Great North Road Solar and Biodiversity Park

Draft Statement of Common Ground with Nottinghamshire County Council

Document reference – EN010162/APP/8.1B

February 2026

**Location of Geophysical Survey and Trenching
Figure 11.2a**

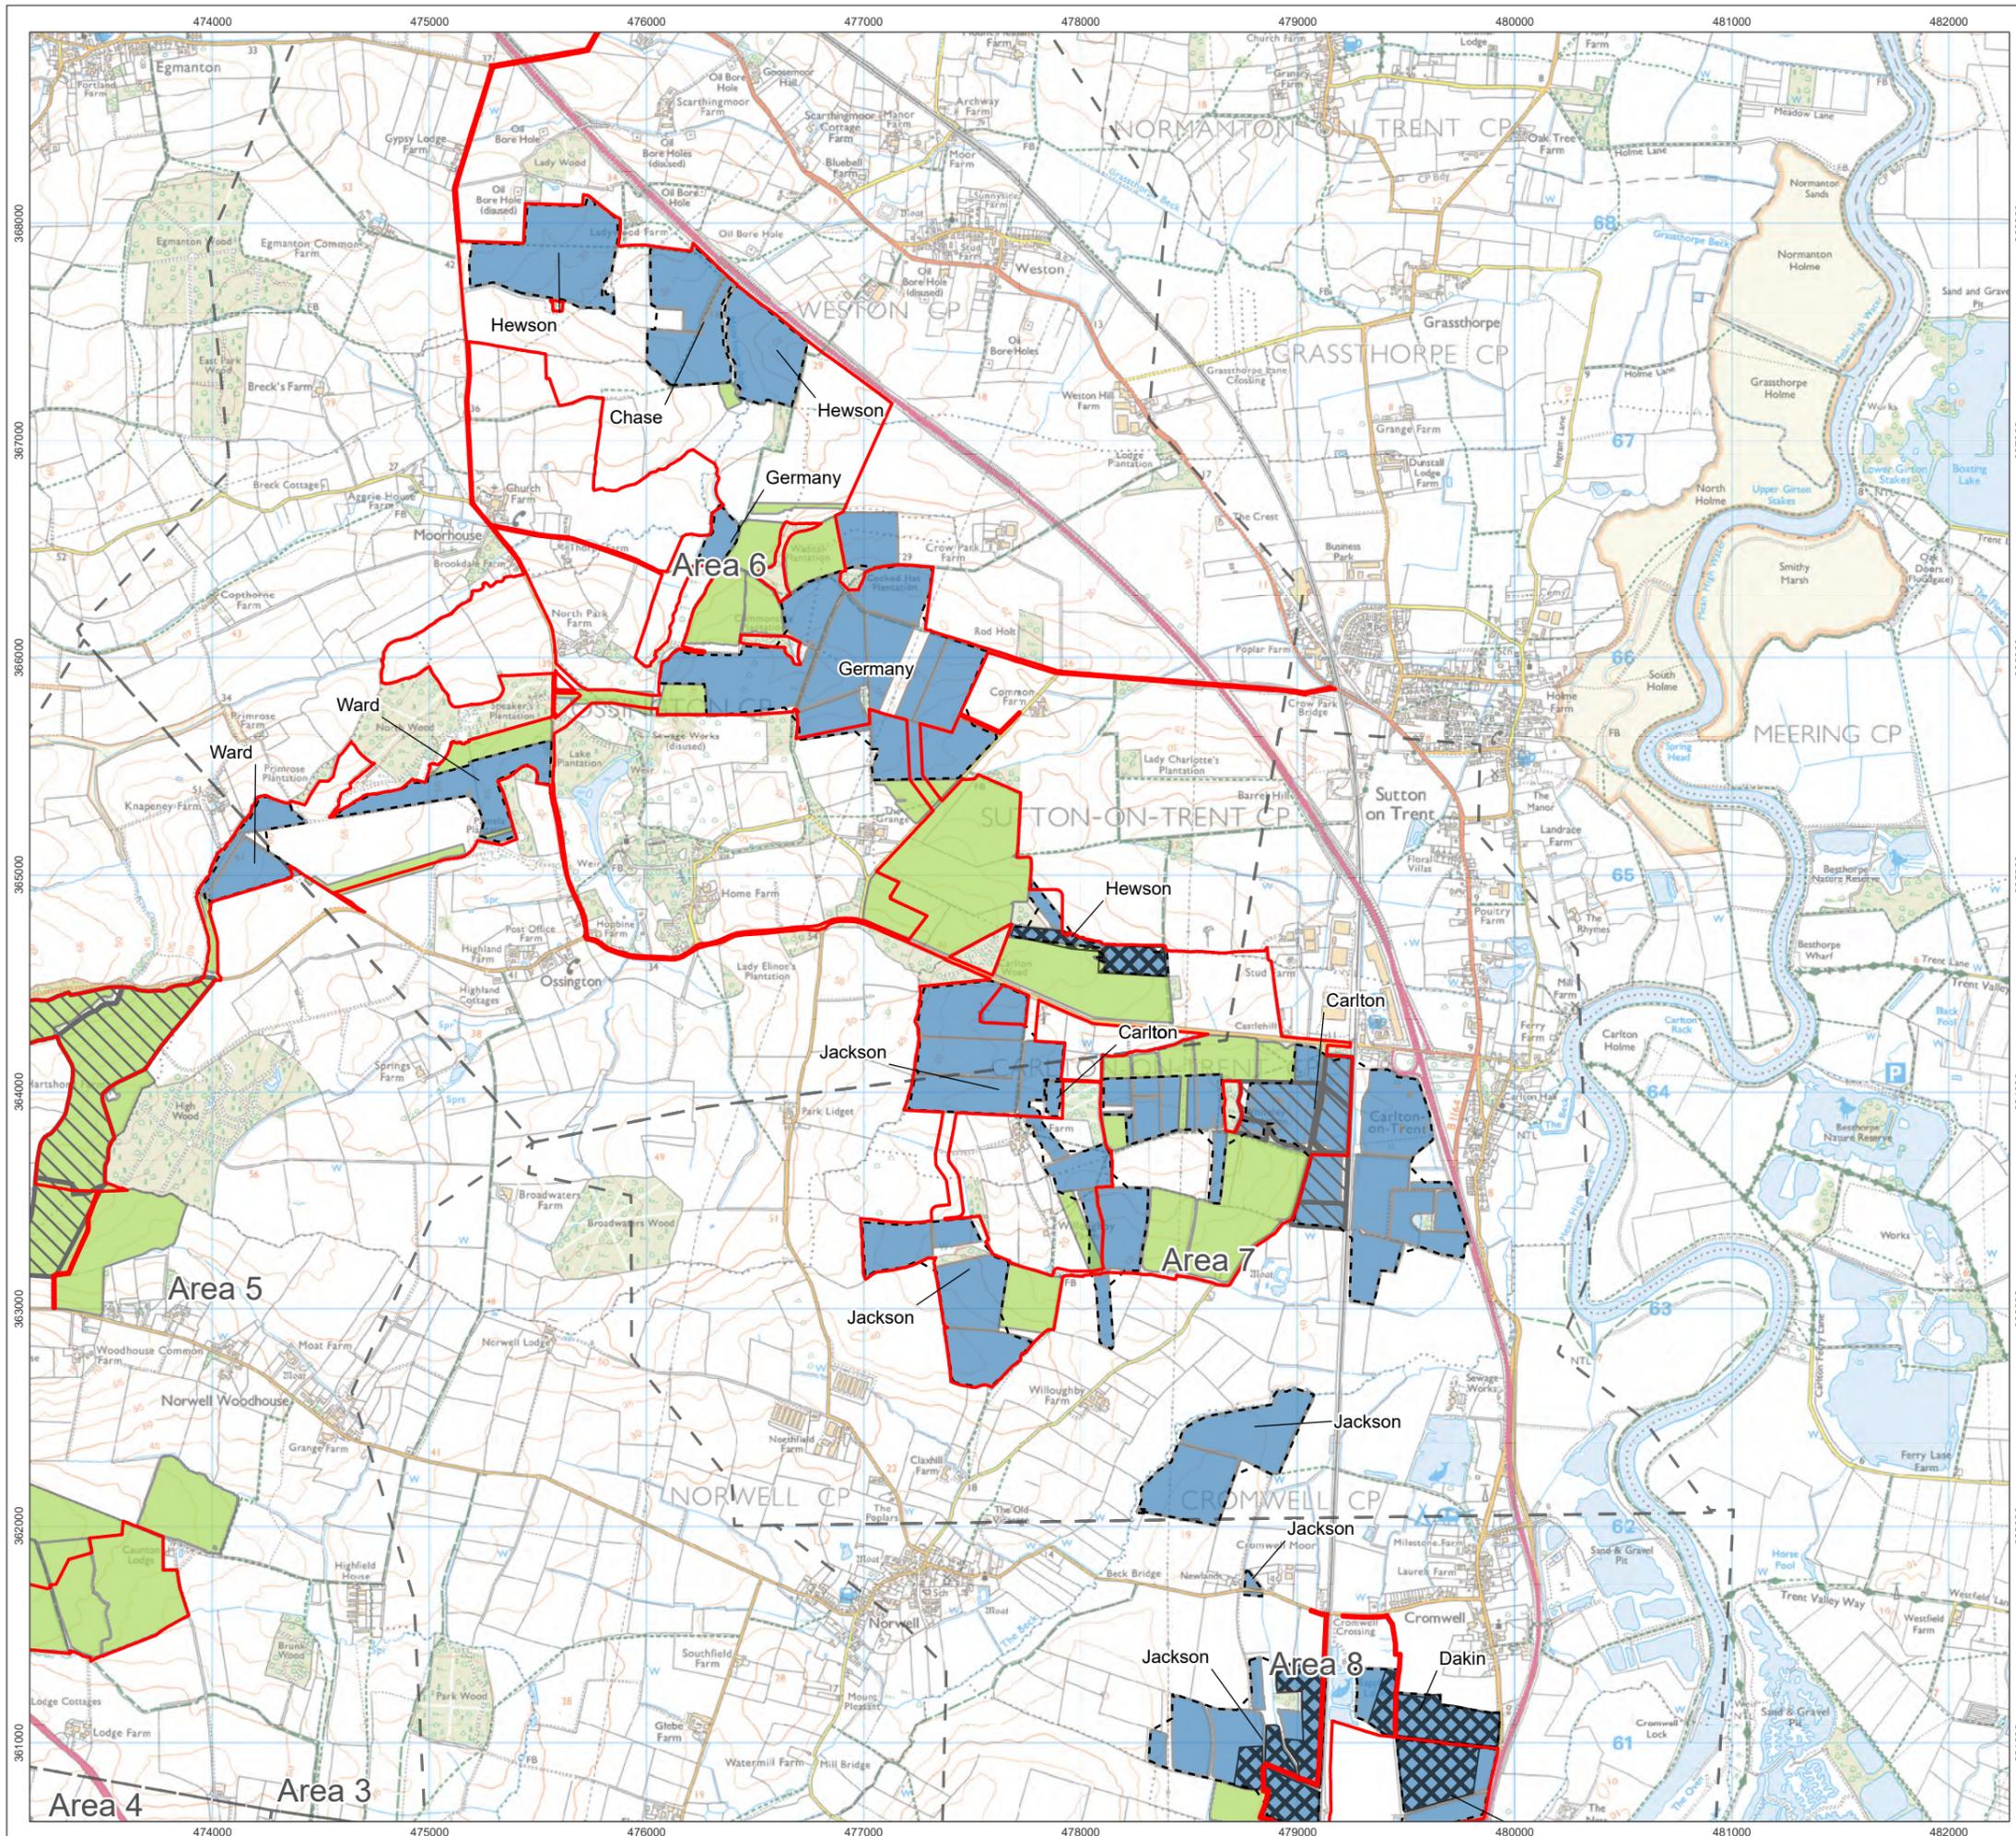
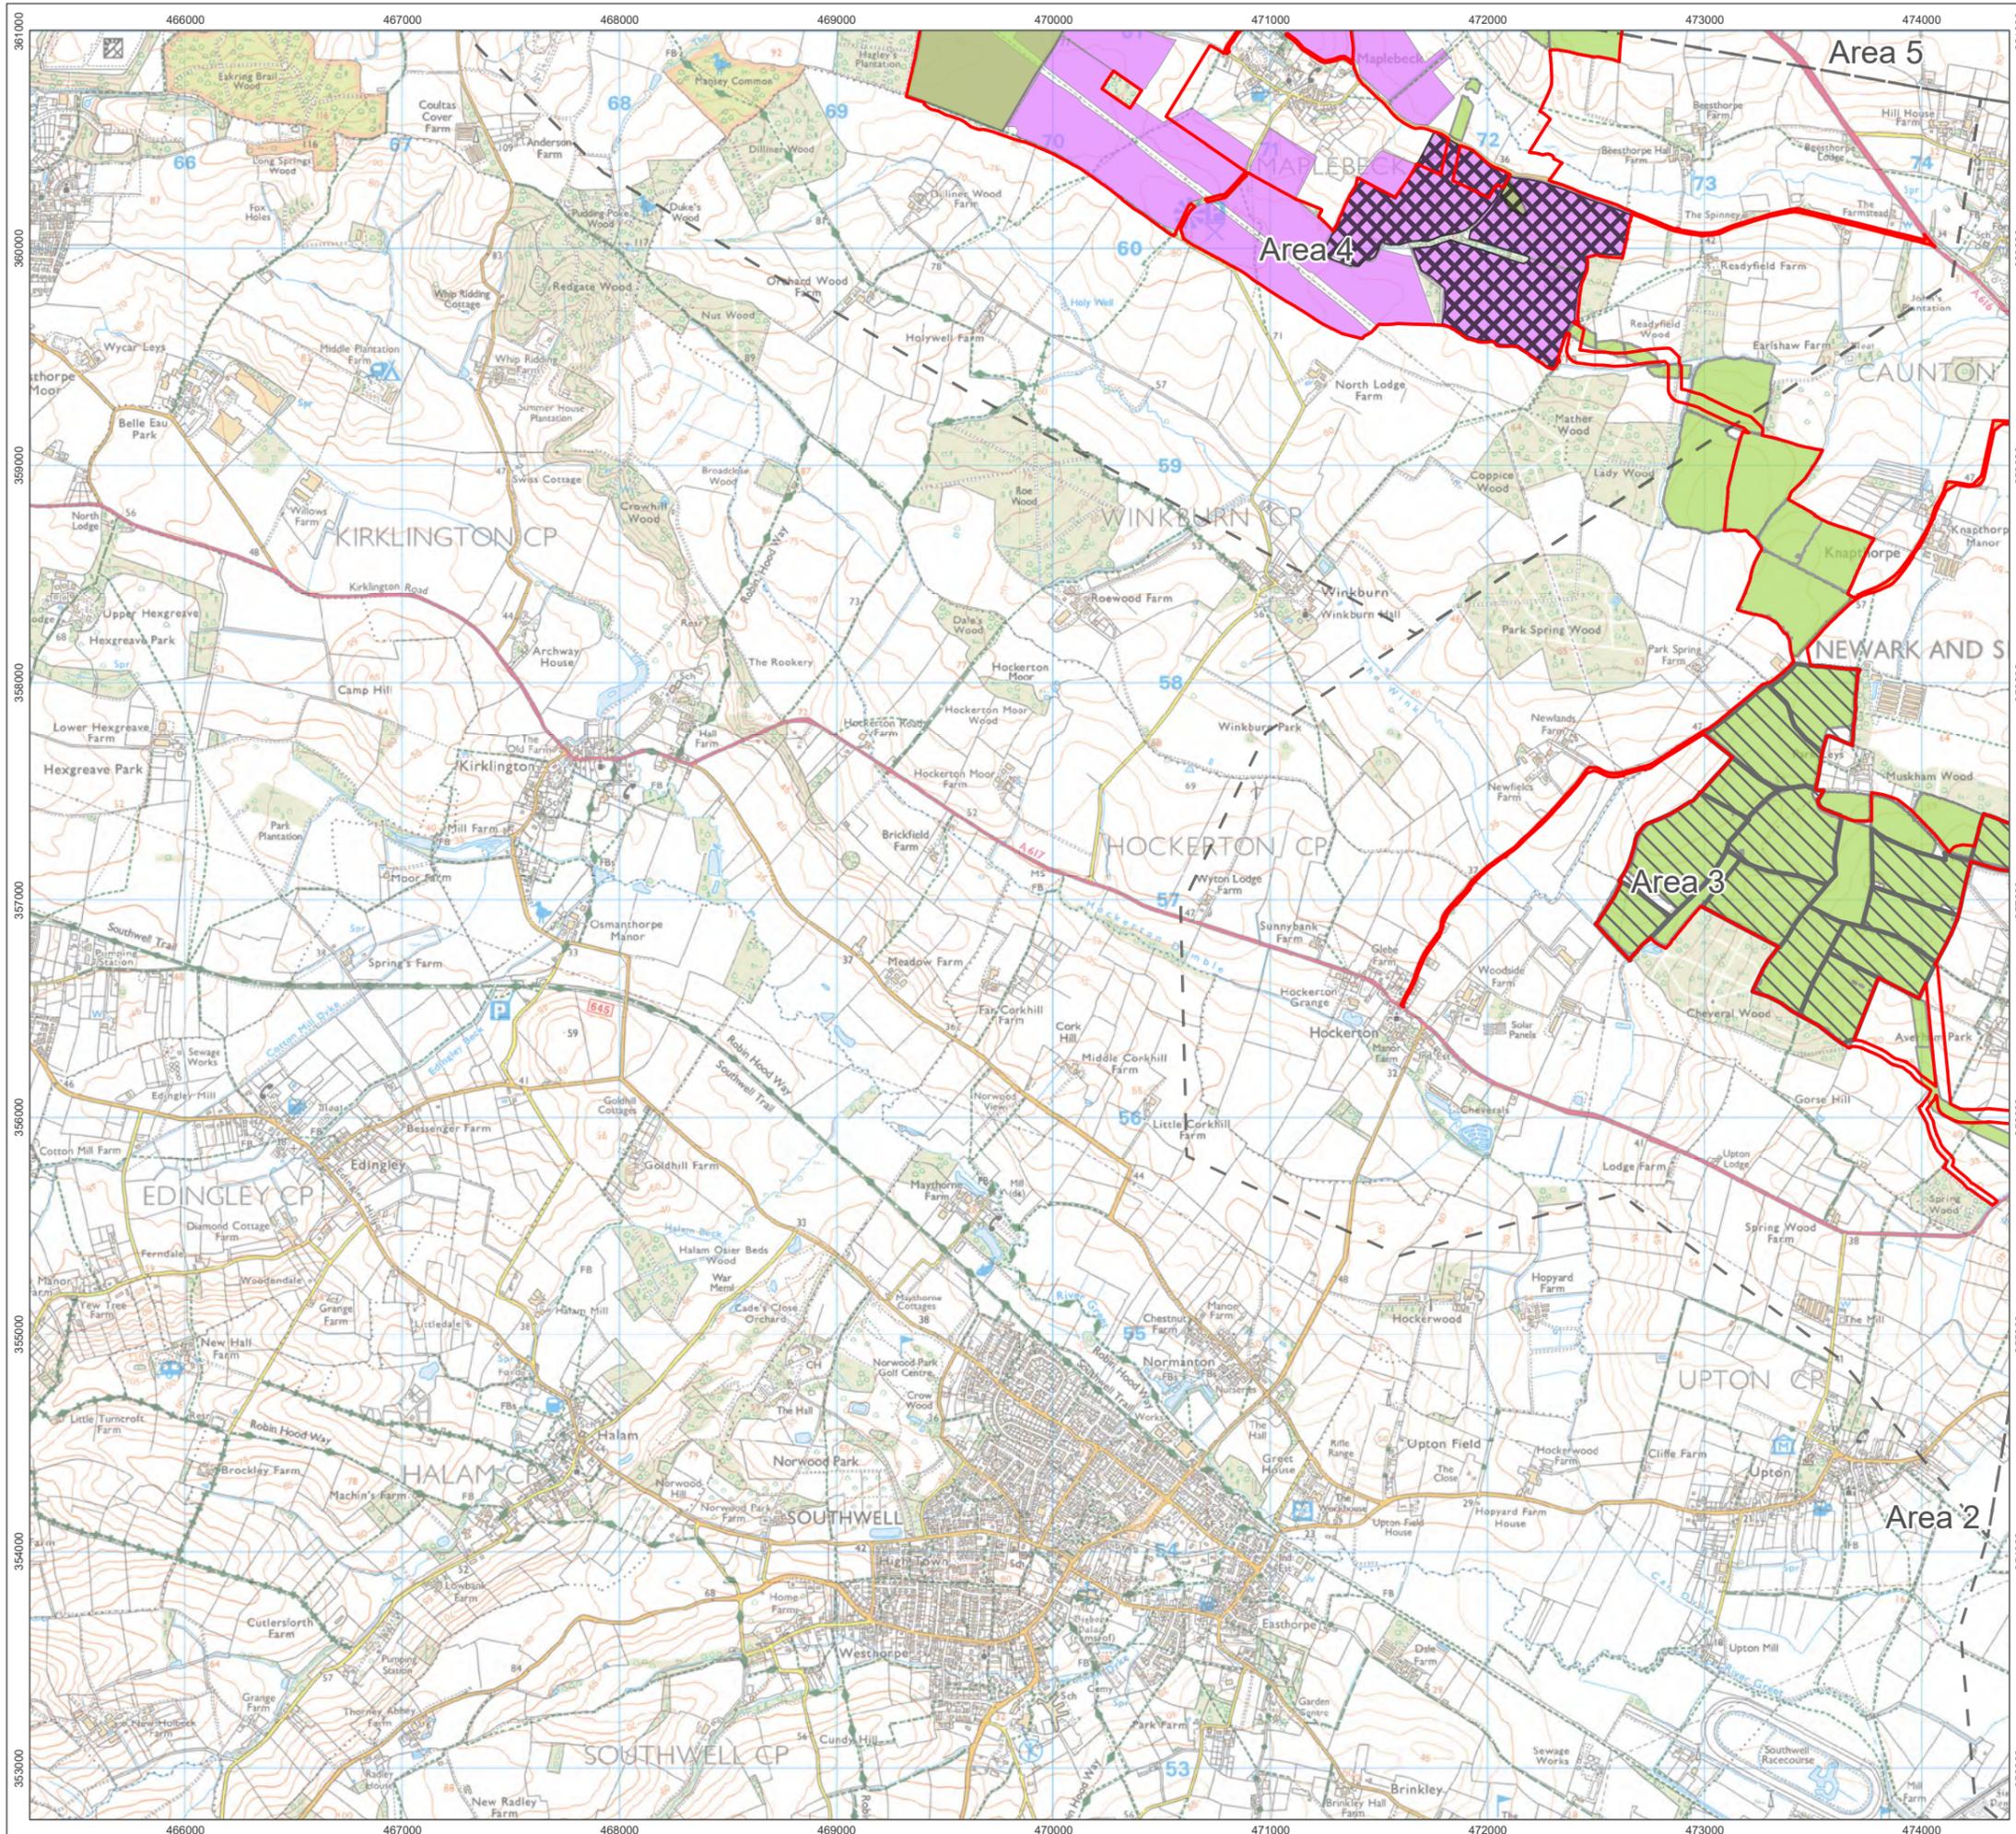
2.2.9	NCC Response to ExQ1	Approach to further Archaeological Assessment	<p><u>Current Position:</u></p> <p>We would recommend that that whole order limits be subject to non-intrusive survey and evaluation trenching at the assessment stage so that the best possible understanding of the archaeological resource be obtained and that this data feed into the design and layout of the scheme. The applicant's approach has been to undertake a full desk-based assessment, a non-intrusive geophysical survey of</p>	Please refer to the response on Trial Trenching below.	Under discussion

Ref	Relevant Documents	Description of Matter	NCC's Position	Applicant's Position	Status
			<p>the majority of the order limits to identify buried remains, (as far as possible within the constraints of the technique) and a targeted trial trench evaluation based on the results of geophysical survey. They have also undertaken evaluation in some 'blank' areas to assess the effectiveness of the geophysics results. The result of the assessment is that the applicant has a reasonably good understanding of the archaeological resource in those areas that they themselves have identified as having a high potential through desk-based and non-intrusive survey. This does constitute large areas of the site but is by no means comprehensive. In our experience, there will be areas of significant archaeological remains within the order limits that have not yet been identified or characterised due to the limitations of geophysical survey techniques. This is due to inherent bias in geophysical data that</p>

Ref	Relevant Documents	Description of Matter	NCC's Position	Applicant's Position	Status
			<p>favours certain types of activities and therefore periods of archaeological activity. Prehistoric activity is often underrepresented in geophysical results and is often only incidentally picked up during evaluation trenching when later activity (often Roman and medieval) is targeted. The applicant has committed to a postconsent phase of evaluation work (nonintrusive survey and trial trench evaluation) to complete the assessment and provide a more comprehensive picture of the archaeological resource within the order limits. We have some concerns on the proposed approach to this, primarily that it still proposes to target areas of geophysical results, but does not propose significant evaluation outside of that. Currently we do not accept that the outline WSI provides for an acceptable post consent scheme of assessment work, but the broad approach to mitigation work is generally agreeable and the fine detail will</p>

Ref	Relevant Documents	Description of Matter	NCC's Position	Applicant's Position	Status
			<p>need to be present in the AMS prior to any construction work commencing. While we welcome the applicant's commitment to complete the assessment work, we maintain that this would be better undertaken prior to the DCO being consented and that a more detailed understanding of the mitigation requirements be obtained and factored into the overall scheme. However, we note that the SoS has recently found splitting the archaeological assessment work to be acceptable on similar schemes.</p>
